KITTITAS COUNTY

MEMORANDUM

TO: All Staff
FROM: Public Works Plan Review Team
DATE: October 5th, 2023
SUBJECT: Public Works Comments: BL-23-00023 M&M Lowe Family LLC

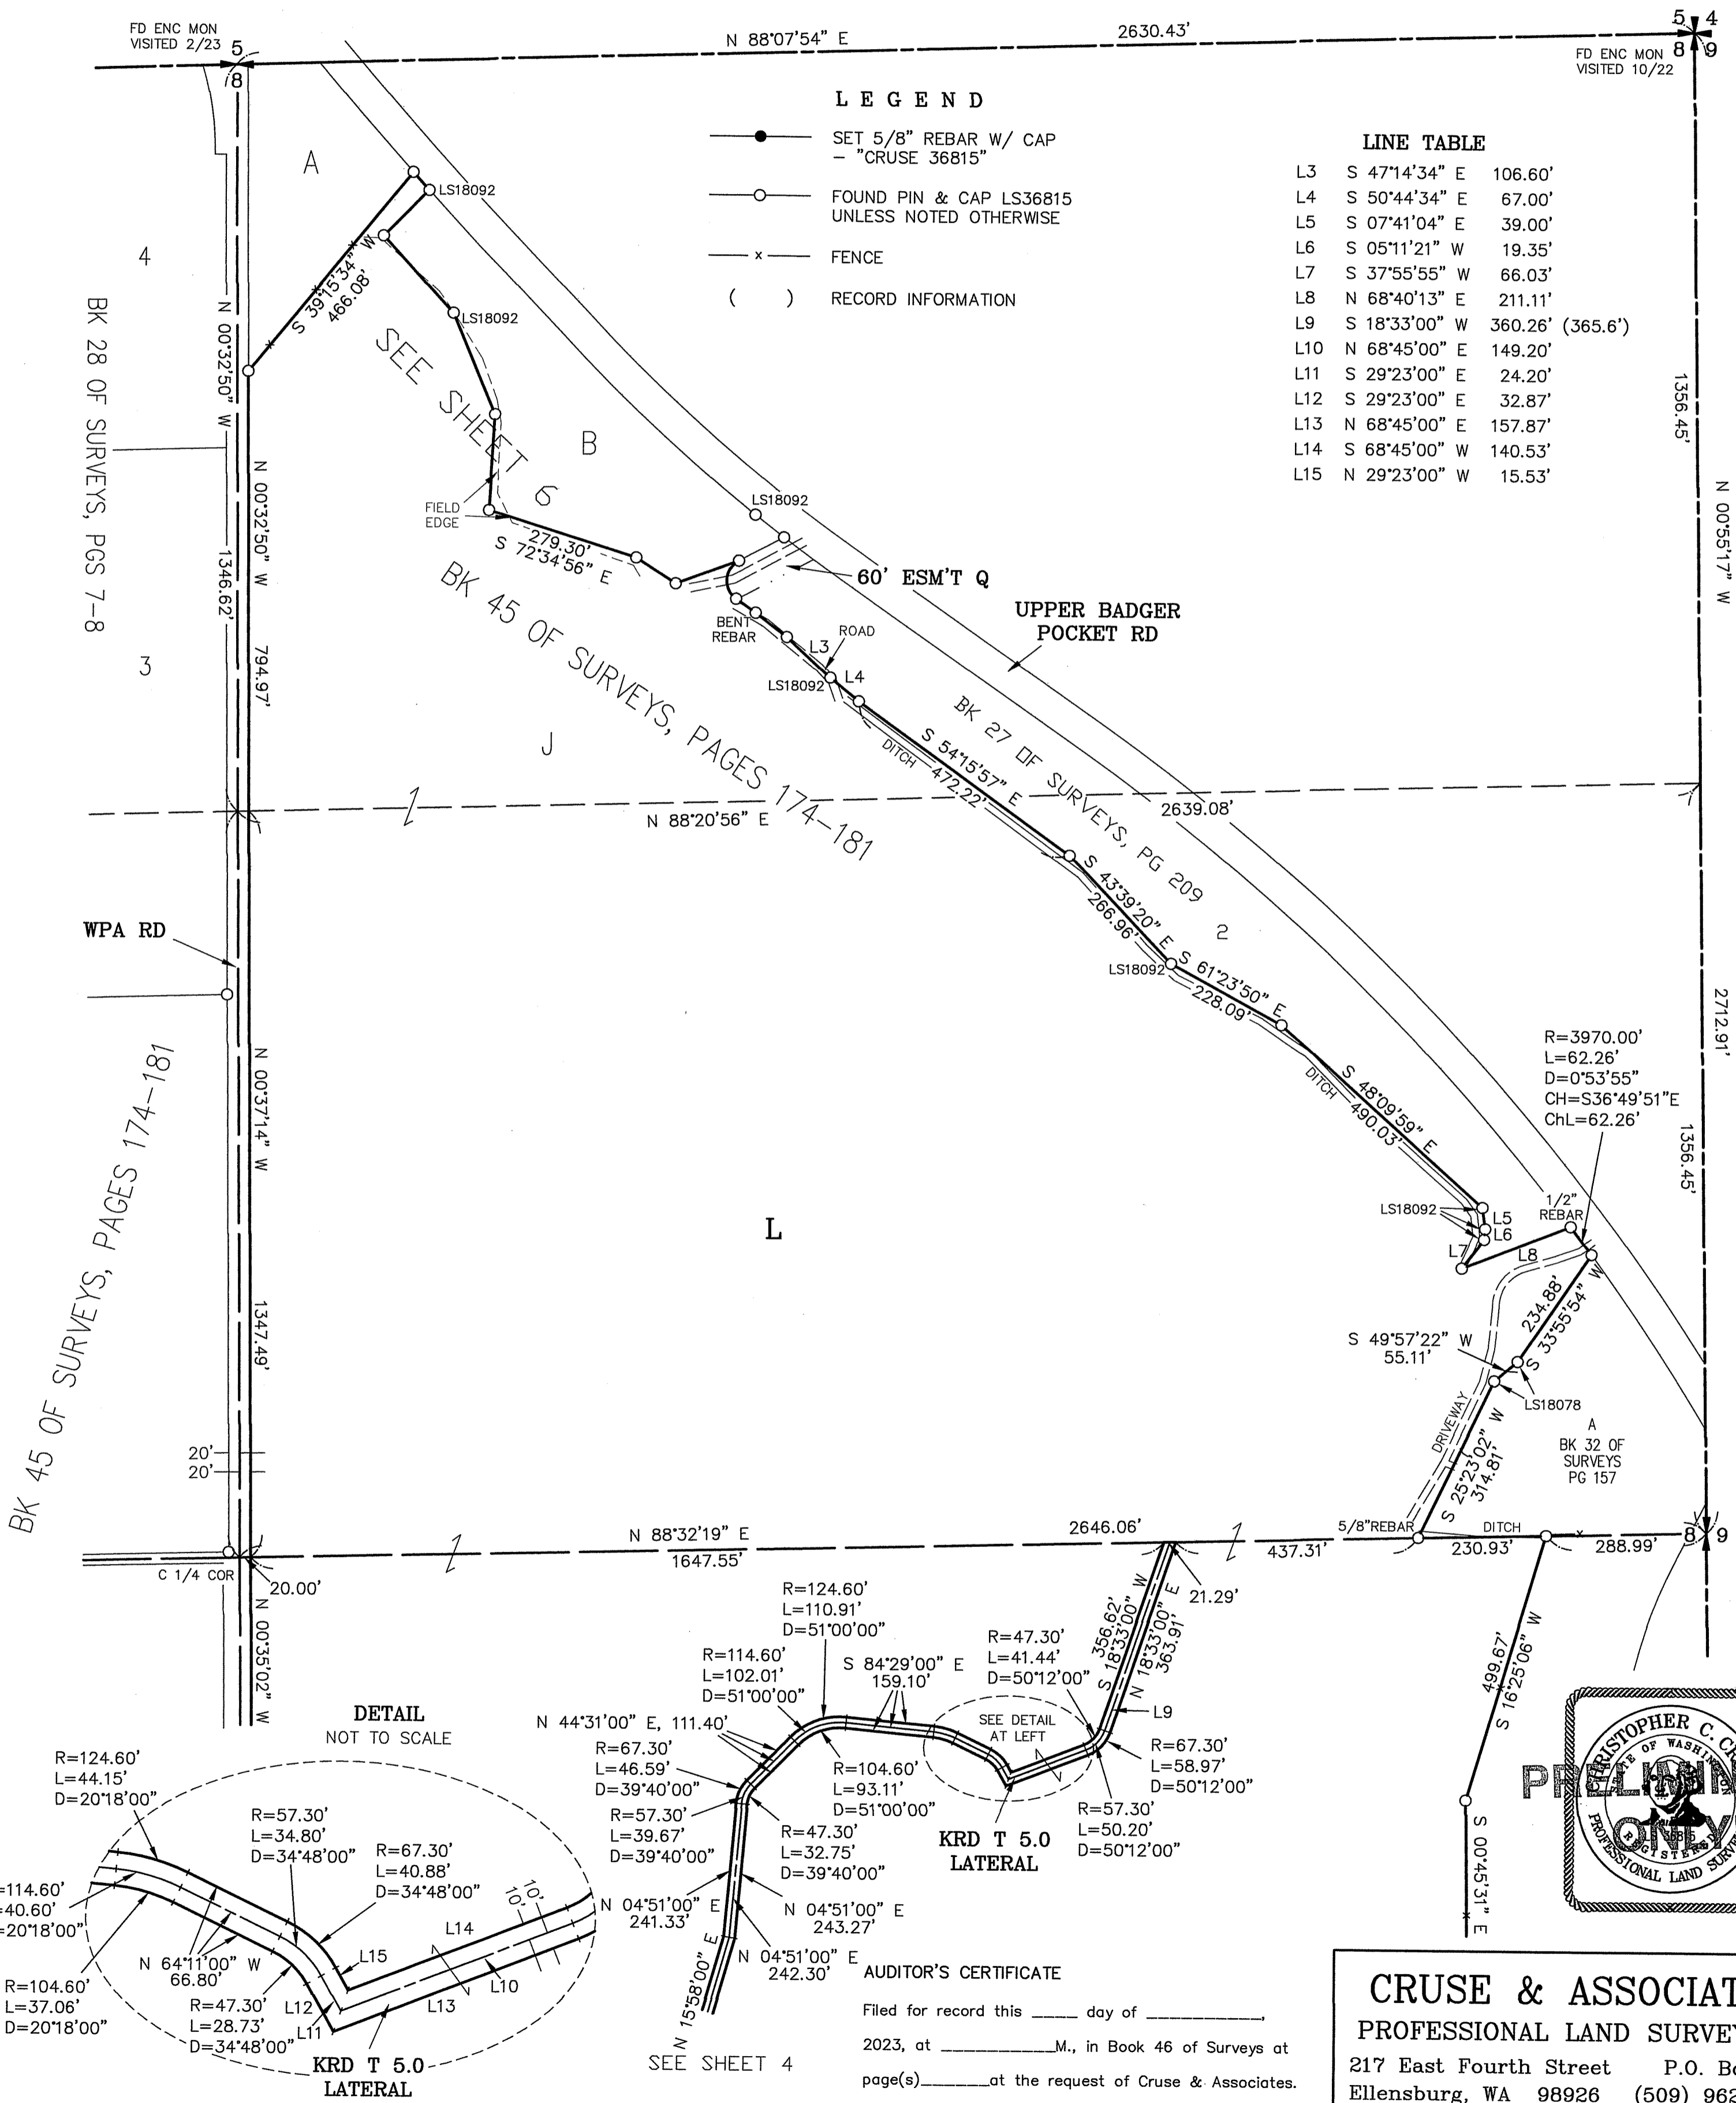
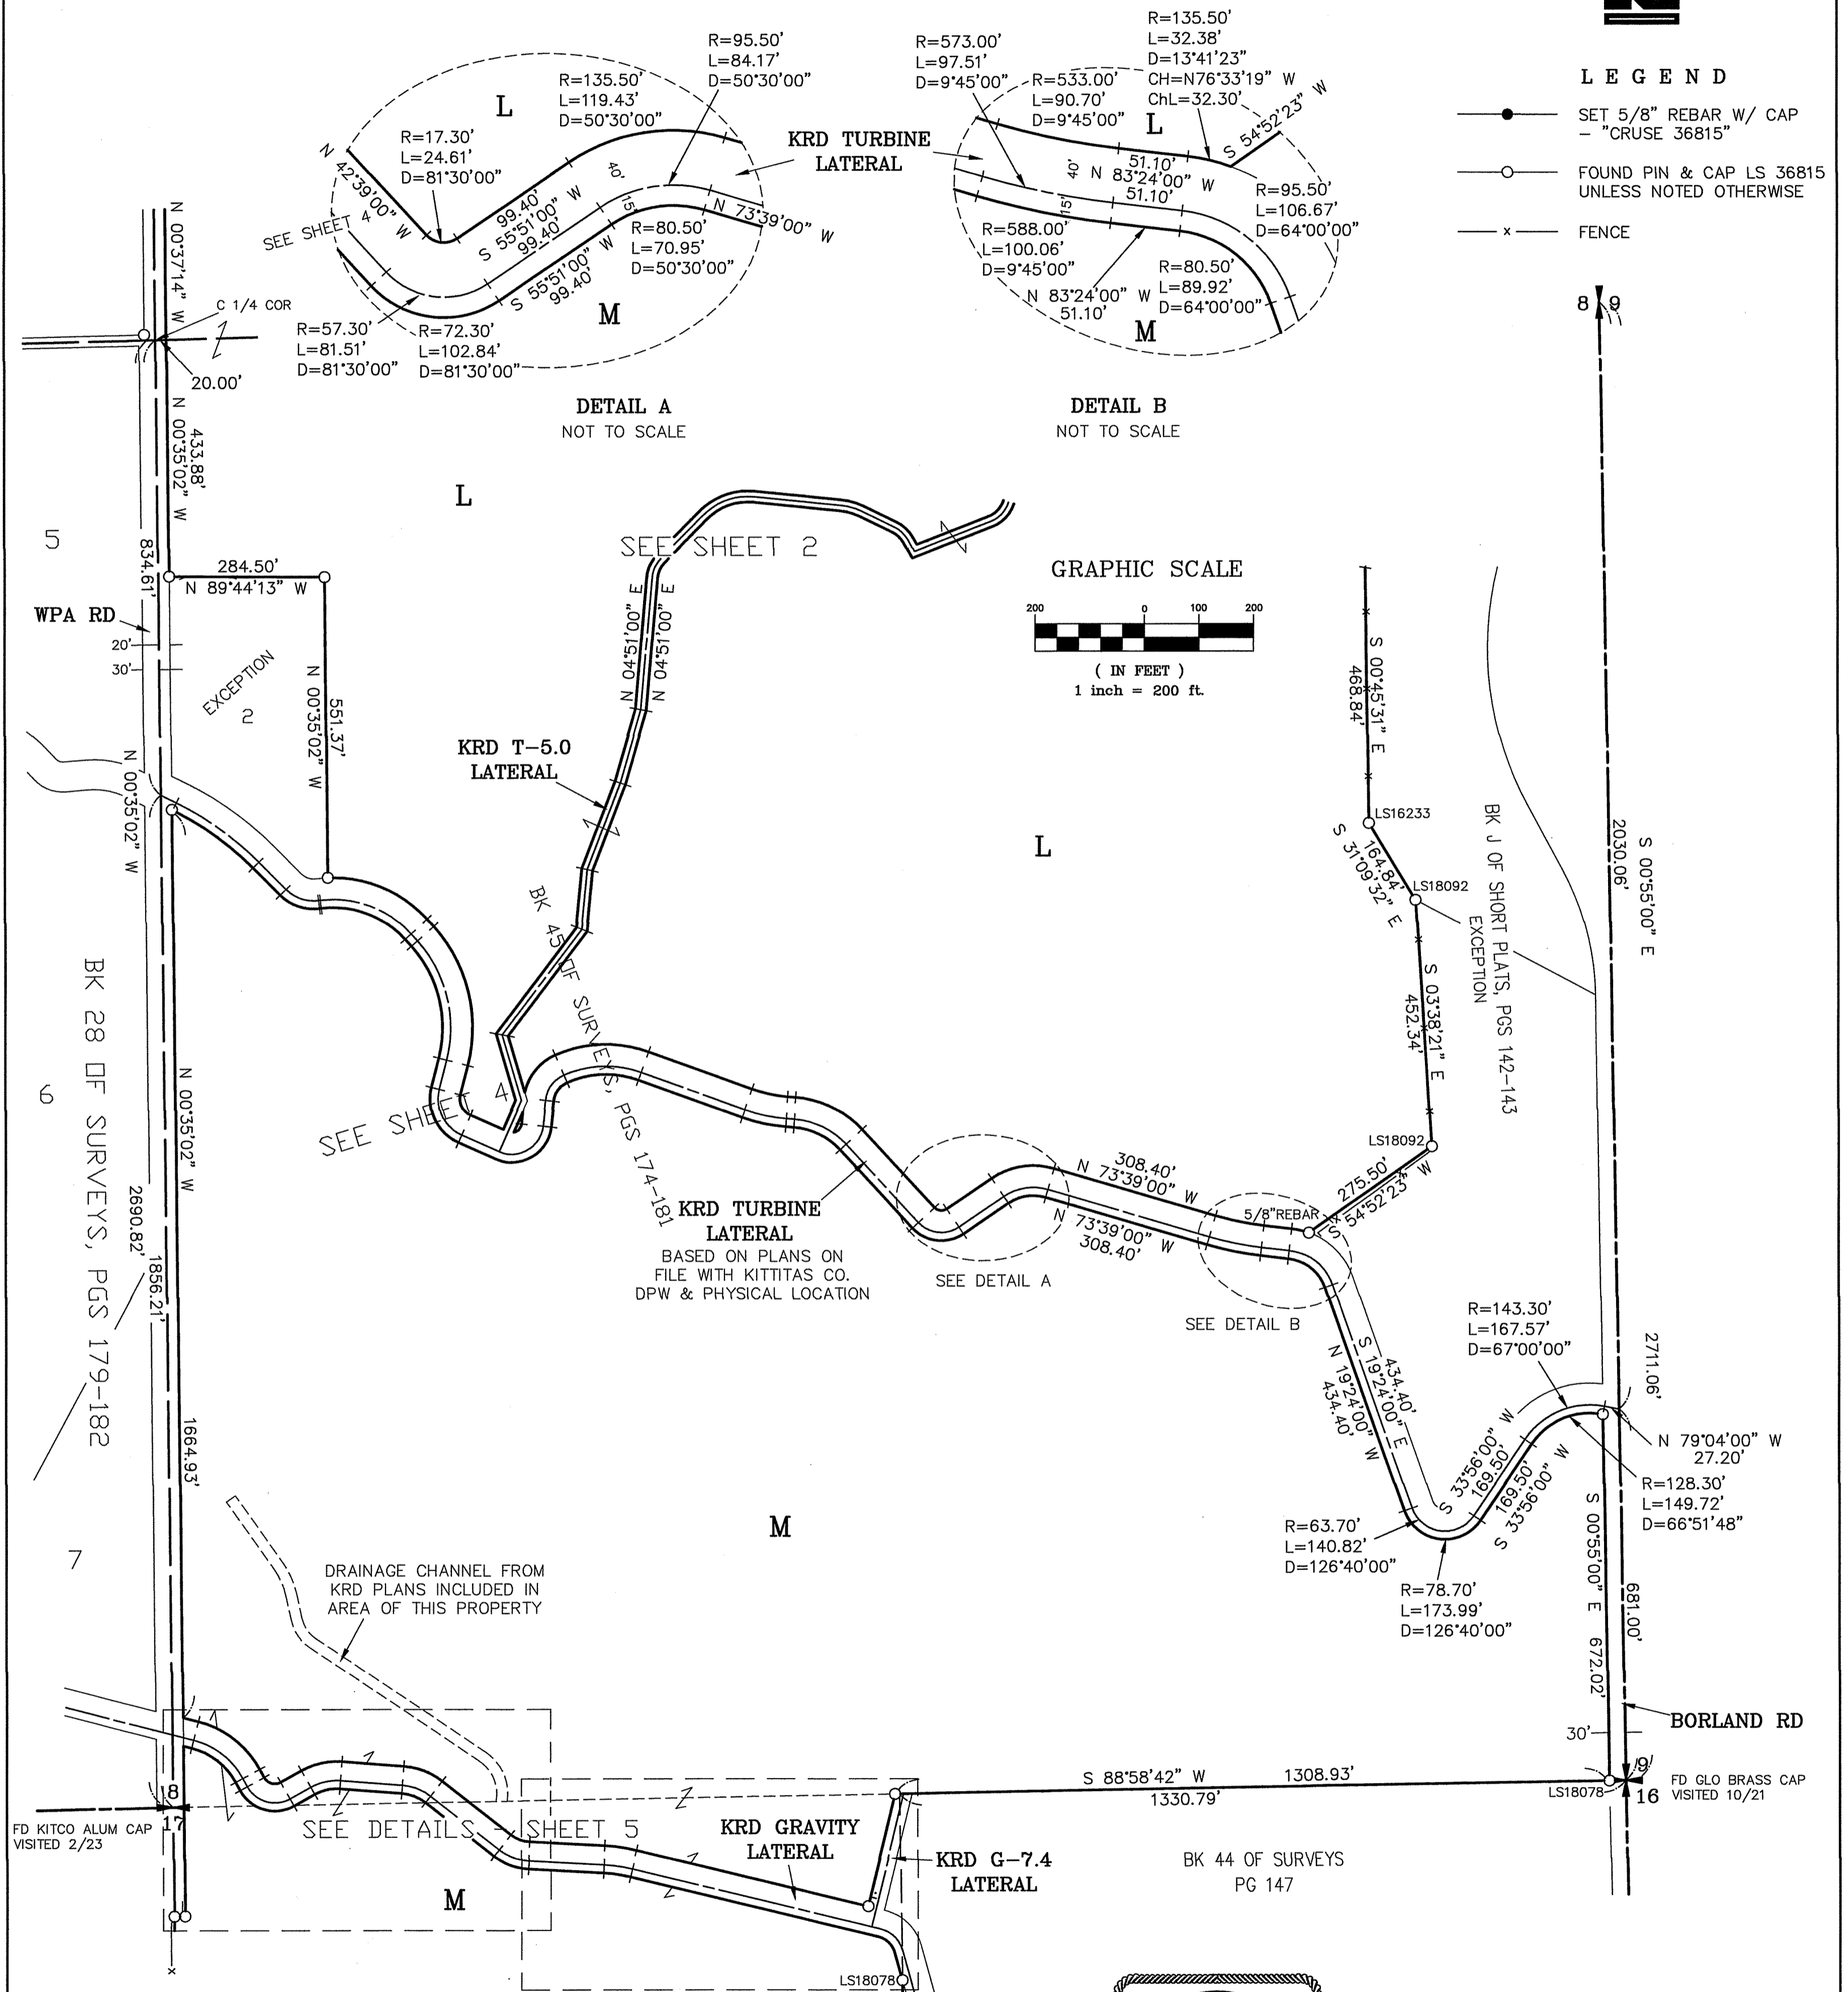
<p>SURVEY</p>	<p>As the application does not contain a survey map, survey reviewed is reserved until final submittal. (JT)</p> <p>UPDATE 11/21/2023</p> <ol style="list-style-type: none"> 1. Please include the R/W width, ownership and surfacing for all roadways. 2. Please show the total distance for the S line of SE1/4 of Section 8. 3. On Sheet 5, Please include the distance along the section line for the E' most portion of Parcel M, in Section 17 N of the lateral (780.56 per the closure rept). 4. Please remove the thin grey line that runs through the legend on Sheet 5. (this may be a result of printing or scanning) 5. (this may be a result of printing or scanning)
